Monument Academy
Traffic Impact Study
PCD File No. U192/PPR19009
(LSC #184820)
April 24, 2019

RE: Monument Academy
El Paso County, Colorado
Traffic Impact Study
LSC #184820

Figure 2

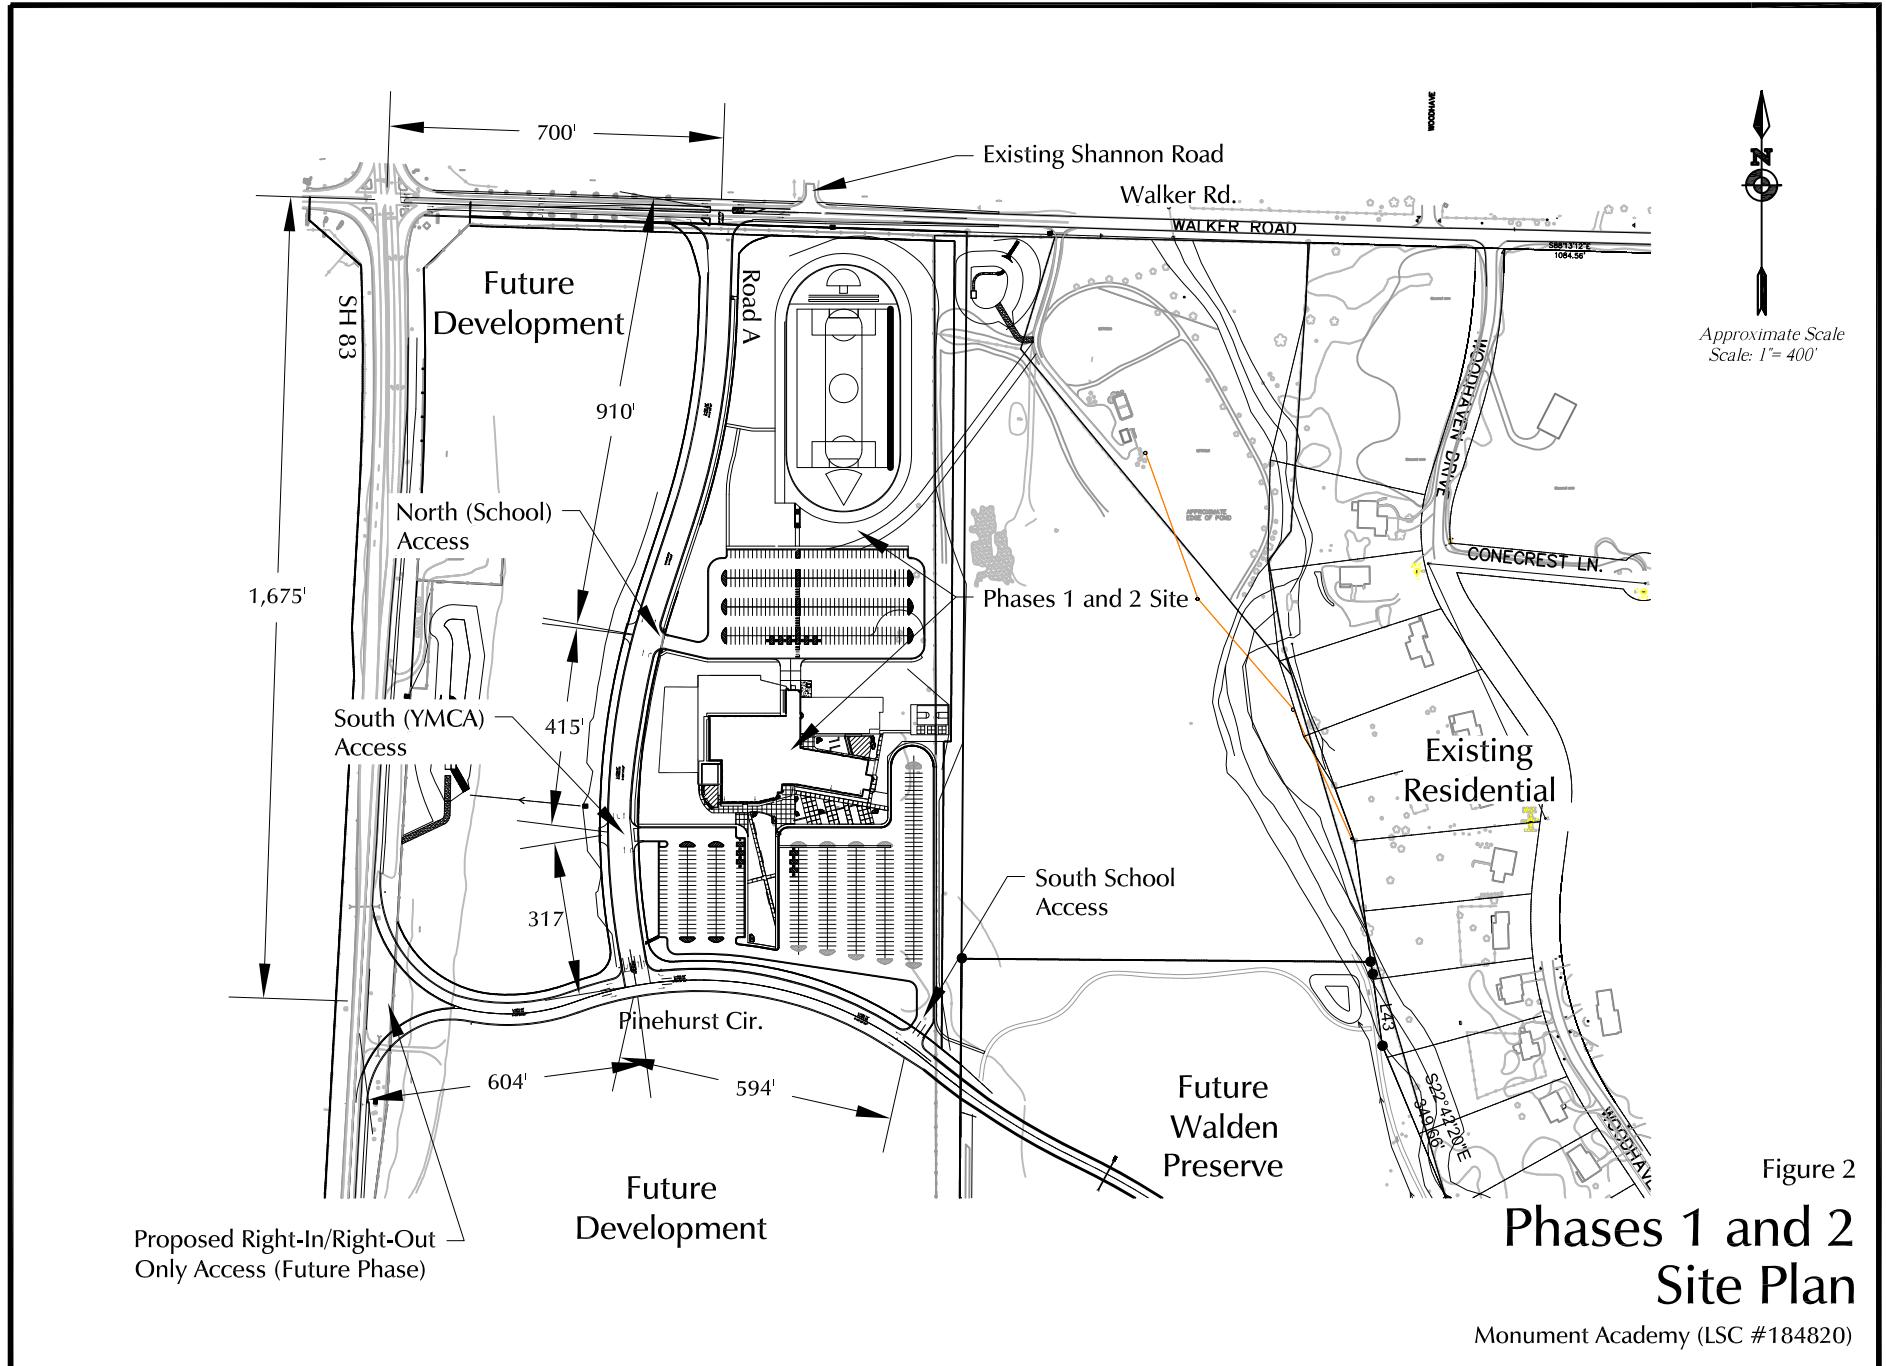
Not shown on SDP. What route would they need to take? How much traffic would go that way if not limited?

Figure 7  
**Sight Distance**  
**YMCA Access**  
 Monument Academy (LSC #184820)

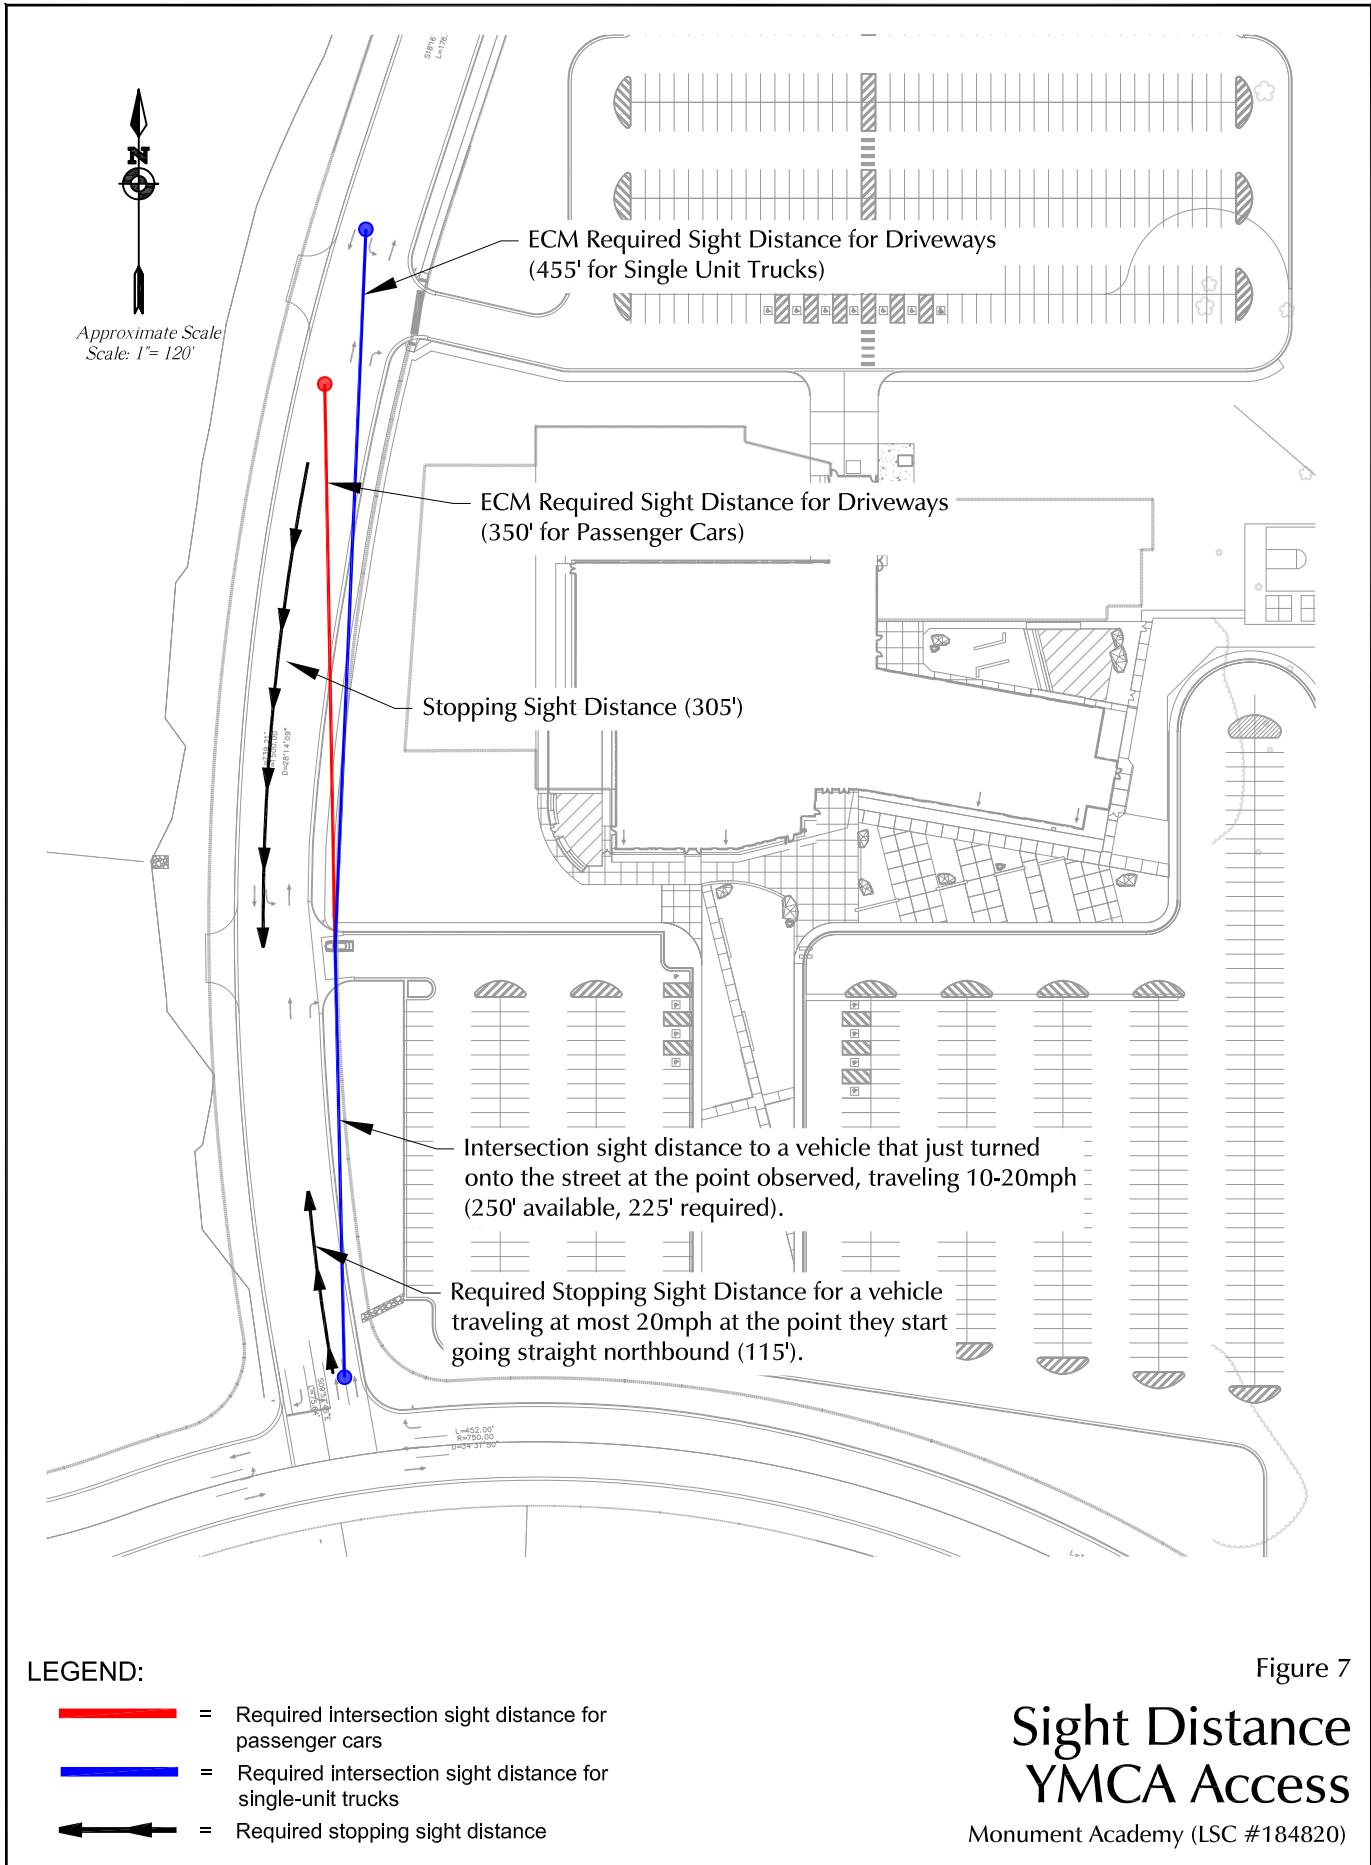
Deviation requested?
